RE: Walker Short Plat (SP-06-41)

The Kittitas County Community Development Services Department has determined that the Walker Short Plat is a complete application and hereby grants **conditional** preliminary approval subject to the following conditions:

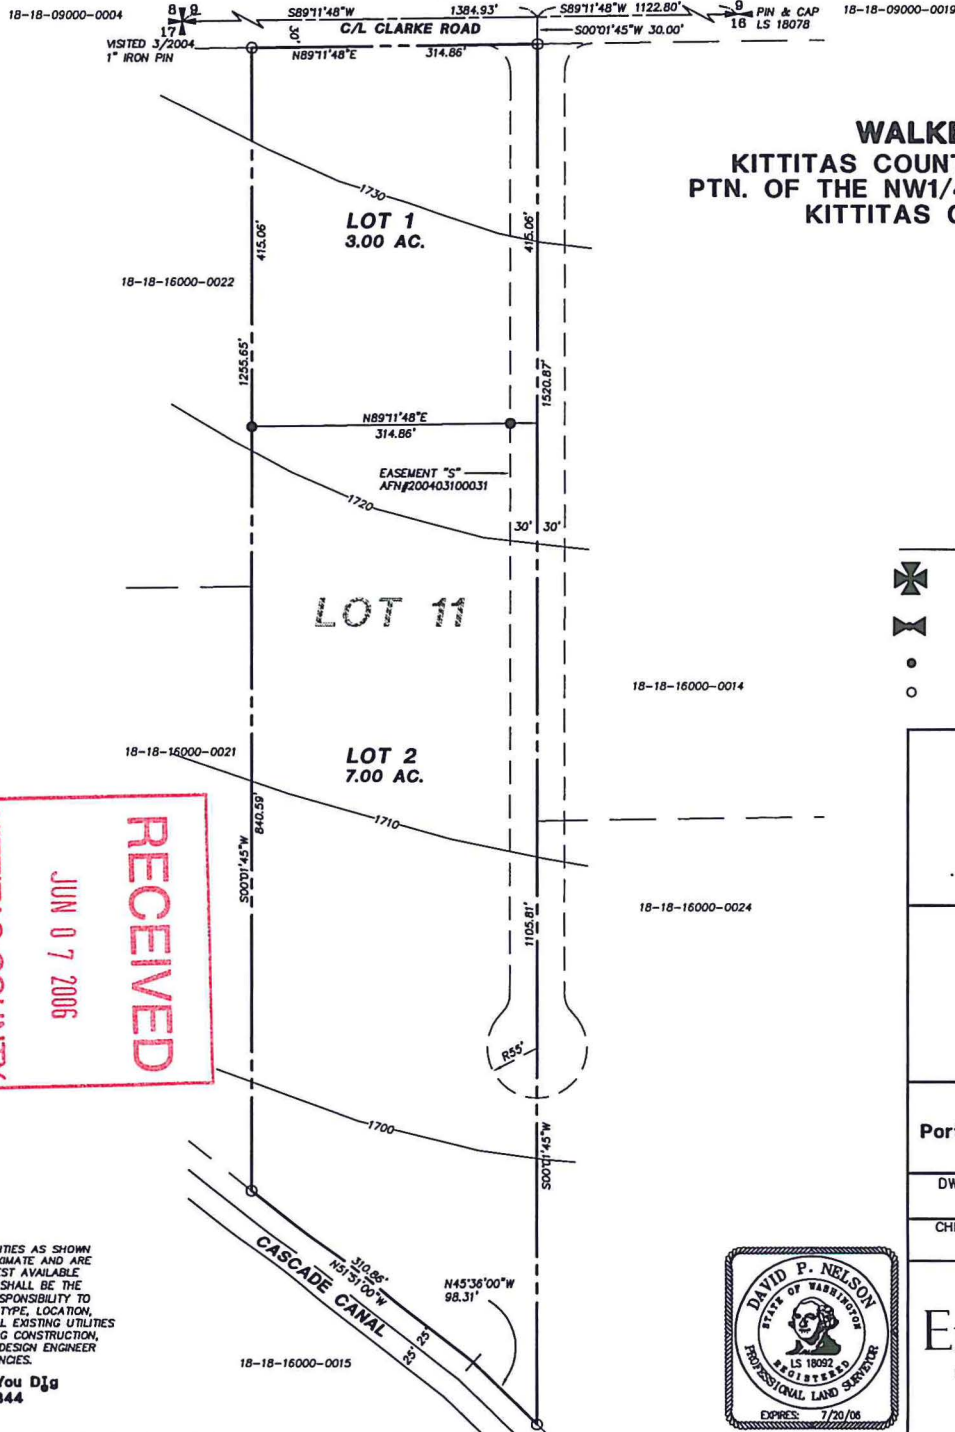
1. Both sheets shall reflect the short plat number SP-06-41.
2. Pursuant to Kittitas County Code 17.74.060A, a Plat Note regarding the Right To Farm Ordinance is required. The note shall read as follows: "The subject property is within or near land used for agriculture on which a variety of commercial activities may occur that are not compatible with residential development for periods of varying duration. (RCW 36.70A.060(1)) Commercial natural resource activities performed in accordance with county, state and federal laws are not subject to legal action as public nuisances." (RCW 7.48.305).

4. Pursuant to Kittitas County Code 16.18.060, a plat note regarding the irrigation systems is required. The note shall read as follows: "Platted lots where the size of the lots is three acres or less shall be irrigated by the use of either a sprinkler irrigation system or a drip irrigation system that meets the requirements of the irrigation entity that supplies the water. (Ord. 2005-31, 2005)."
